Report of the Head of Planning, Sport and Green Spaces

Address 14 MOORFIELD ROAD COWLEY

Development: 2 x single storey side extensions (Application for a Certificate of Lawful Development for a Proposed Development)

LBH Ref Nos: 69313/APP/2013/1907

PROPOSED FRONT ELEVATION 1:100 SCALE

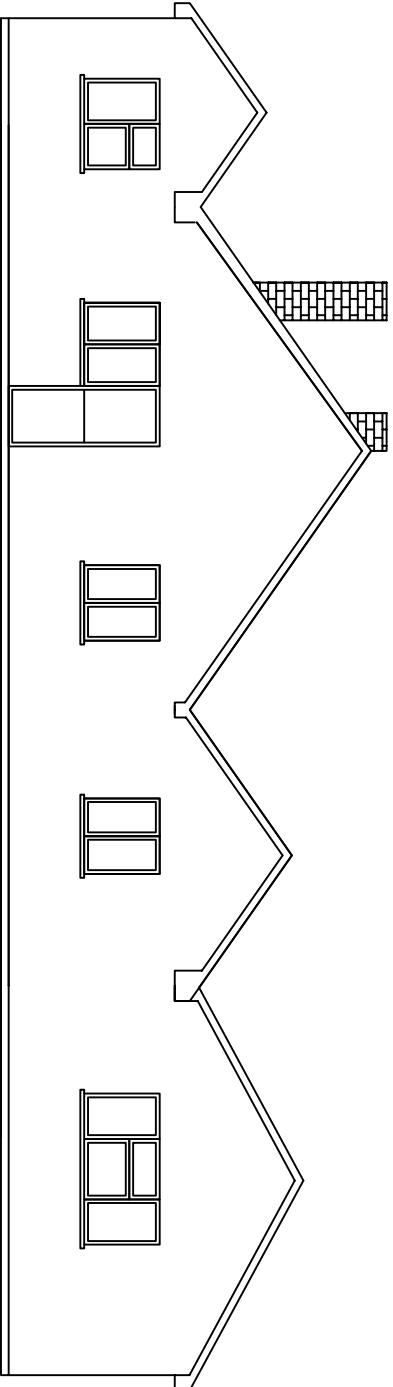
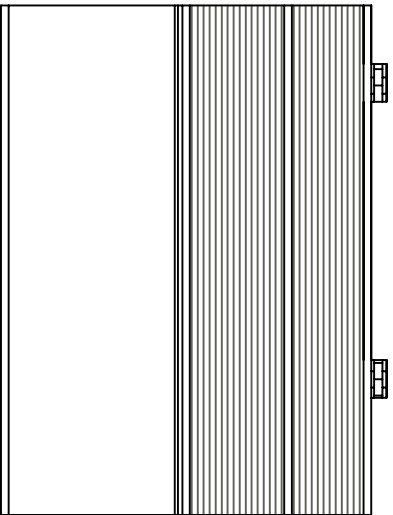
NO (eaves, approx. 2.55m)

PROPOSED FLOOR PLAN 1:100 SCALE

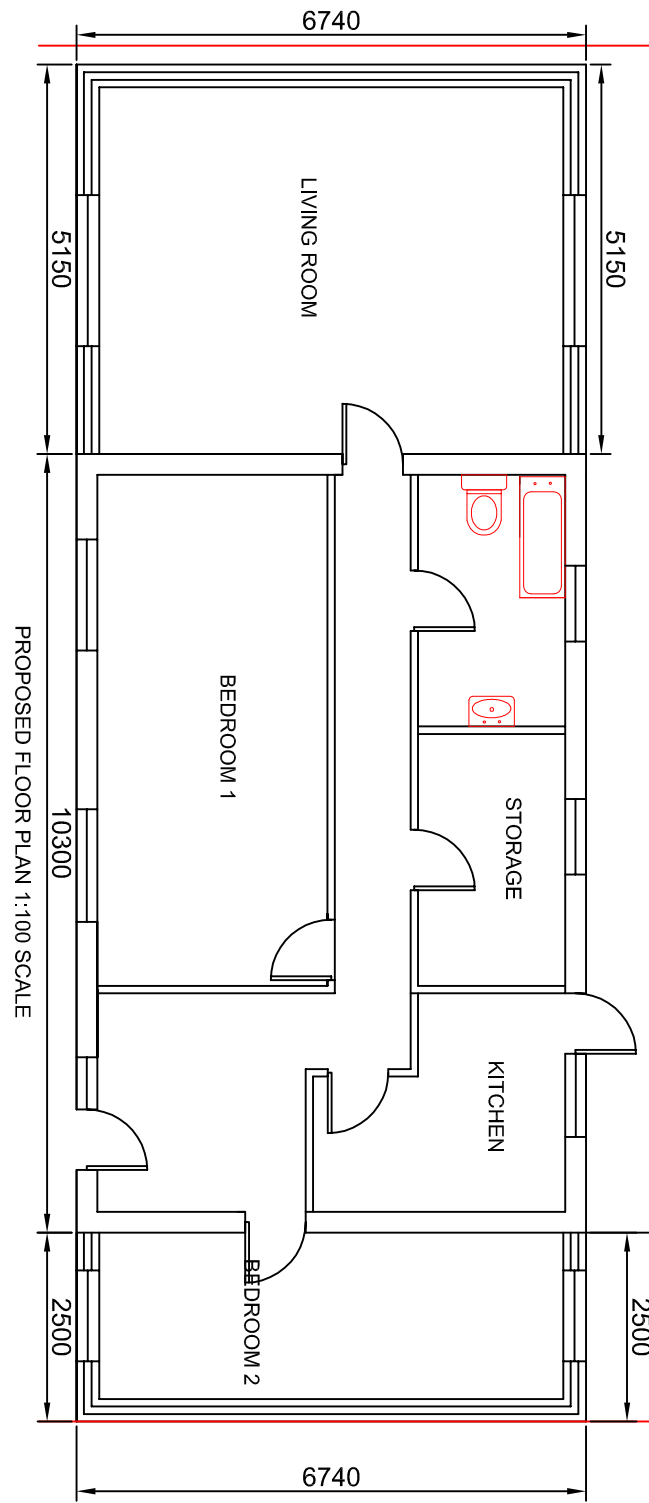
The proposed development does not constitute permitted development by virtue of the provisions of Schedule 2, Part 1, Class A.1(h) of the Town and Country Planning (General Permitted Development) Order 1995 as amended by the Town and Country Planning (General Permitted Development) (Amendment) (No2) (England) Order 2008 as the width of the enlarged parts of the dwellinghouse would extend beyond a wall forming the side elevations of the original dwellinghouse and would have a width greater than half the width of the original dwellinghouse.

In this instance, there are two side extensions proposed, the combined width of which (7.65 metres), thus forming the enlarged part of the dwellinghouse, would have a width greater than half that of the original dwellinghouse (10.3m). As such, whilst each of these additions is capable of being considered lawful in itself, the two additions together are not.

(ii) have a width greater than half the width of the original dwellinghouse; or

YES
